EIAR Addendum

Further information

Milford Quarries Limited
Proposed Quarry Development

This Environmental Impact Assessment Report (EIAR) Addendum has been prepared by Enviroguide Consulting on behalf of Milford Quarries Limited (the Applicant) in support of a planning application for a quarry submitted to Carlow County Council (planning application reference 23/60042).

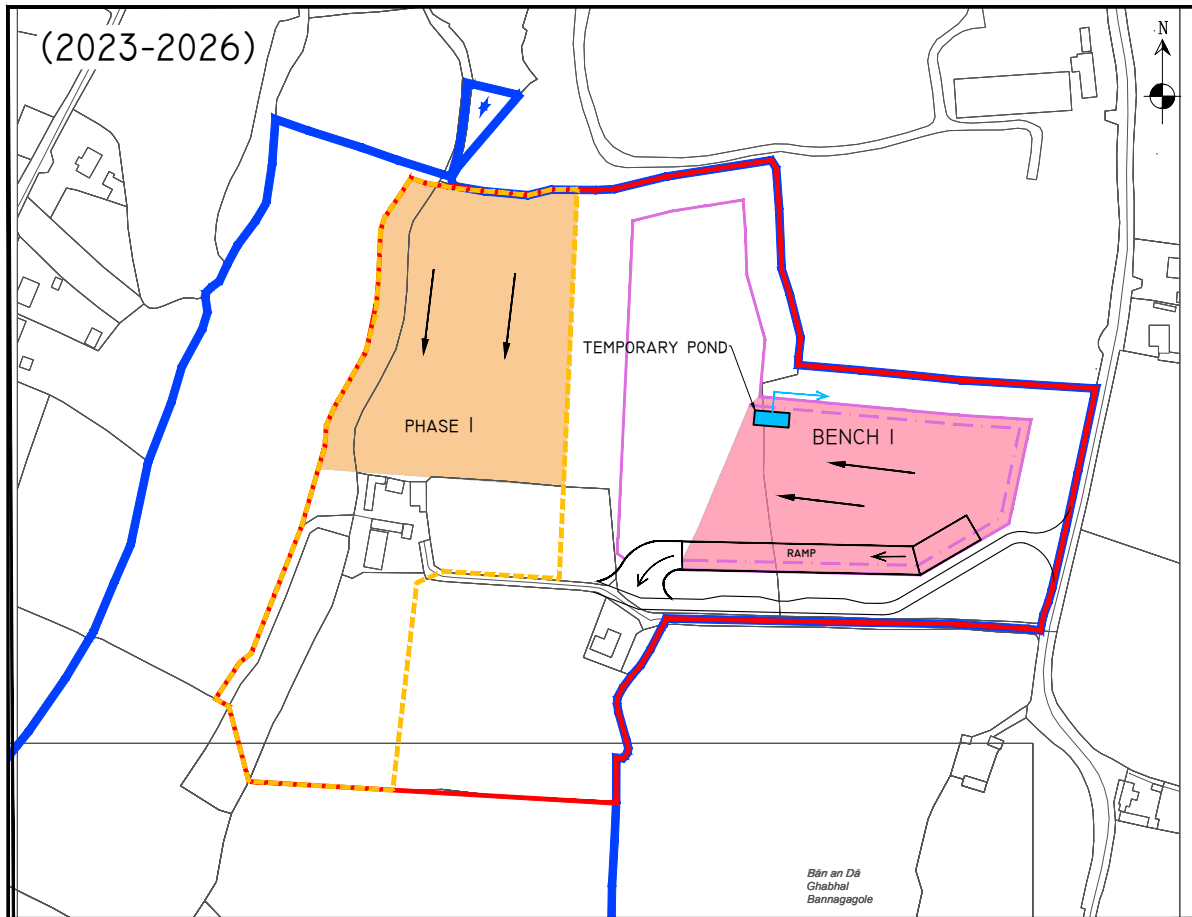
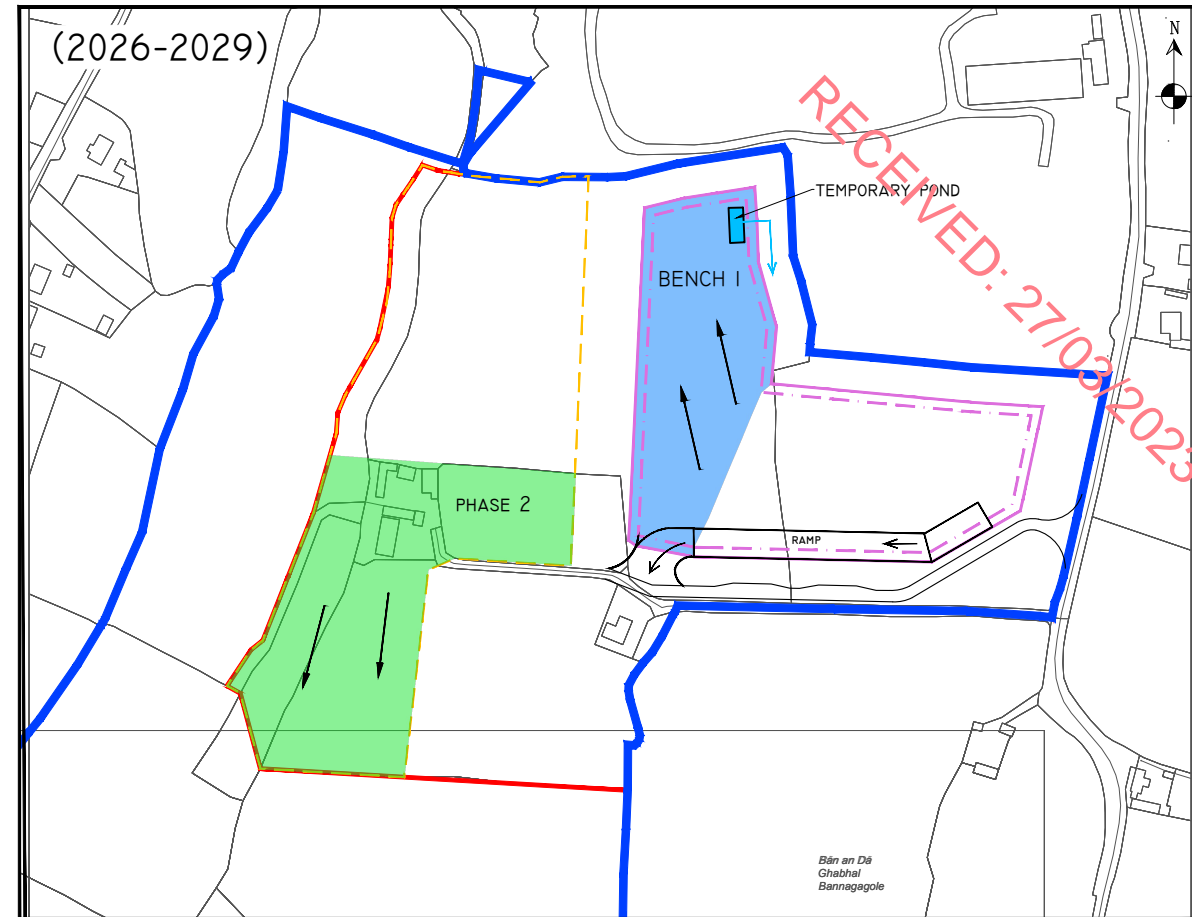
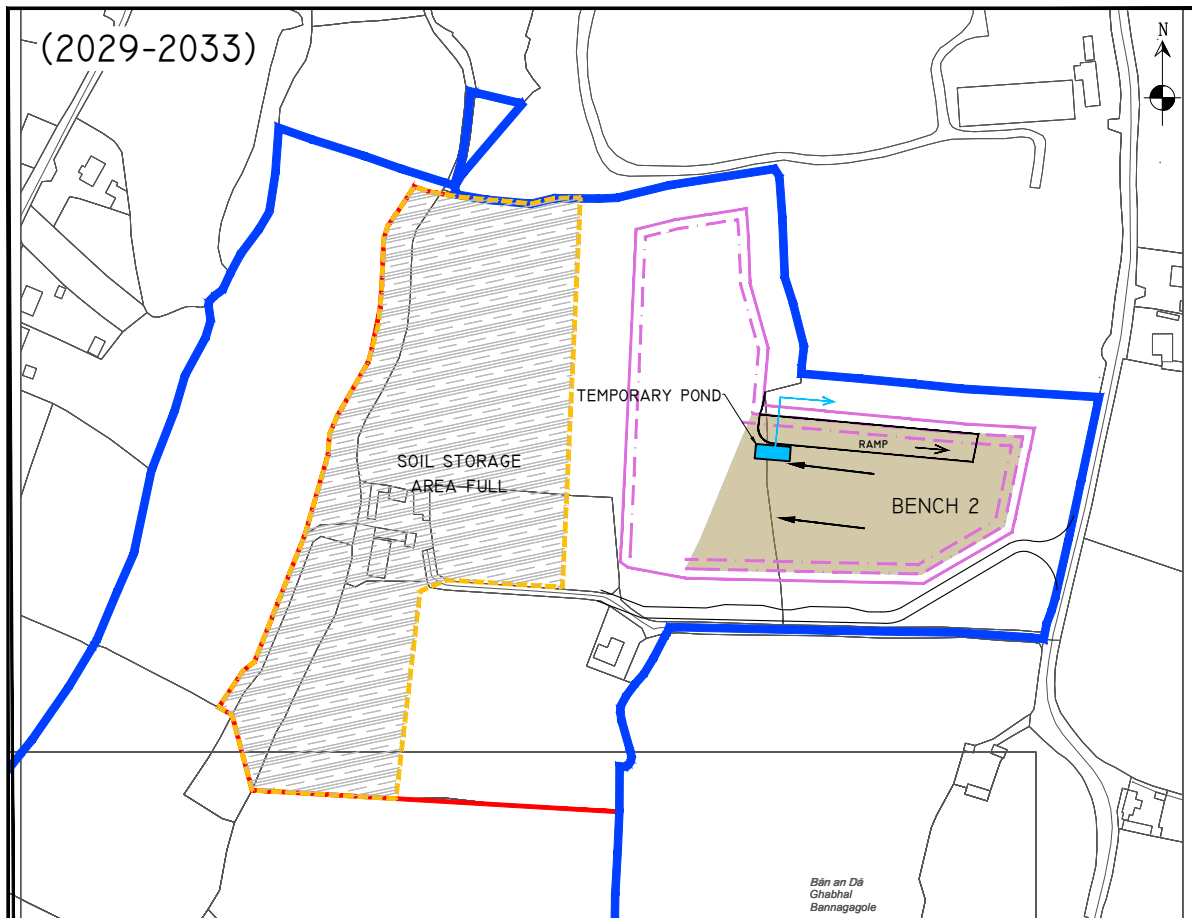
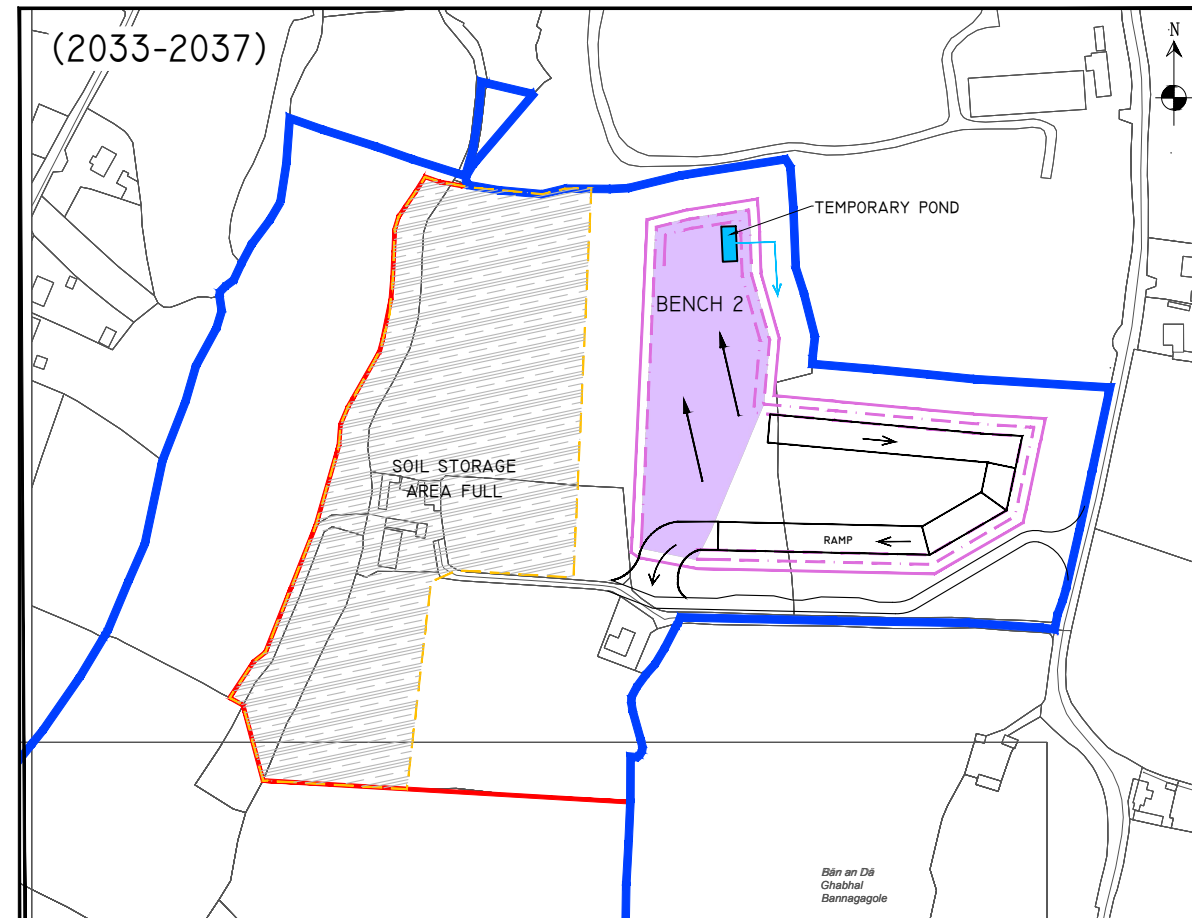
The EIAR does not detail the impacts expected during the restoration and post restoration (decommissioning) phases of the proposed development.

- *The details provided on the proposed restoration of the site are limited despite these works forming part of the development description set out in the public notices. In addition, the indicative restoration plan submitted is not annotated to include predicted ground levels. Full detailed proposals are required for the restoration and post restoration (decommissioning) of the site, together with confirmation as to whether imported materials will/will not be required to facilitate restoration.*

The restoration phases have been designed and are included in Appendix A of this EIAR Addendum.
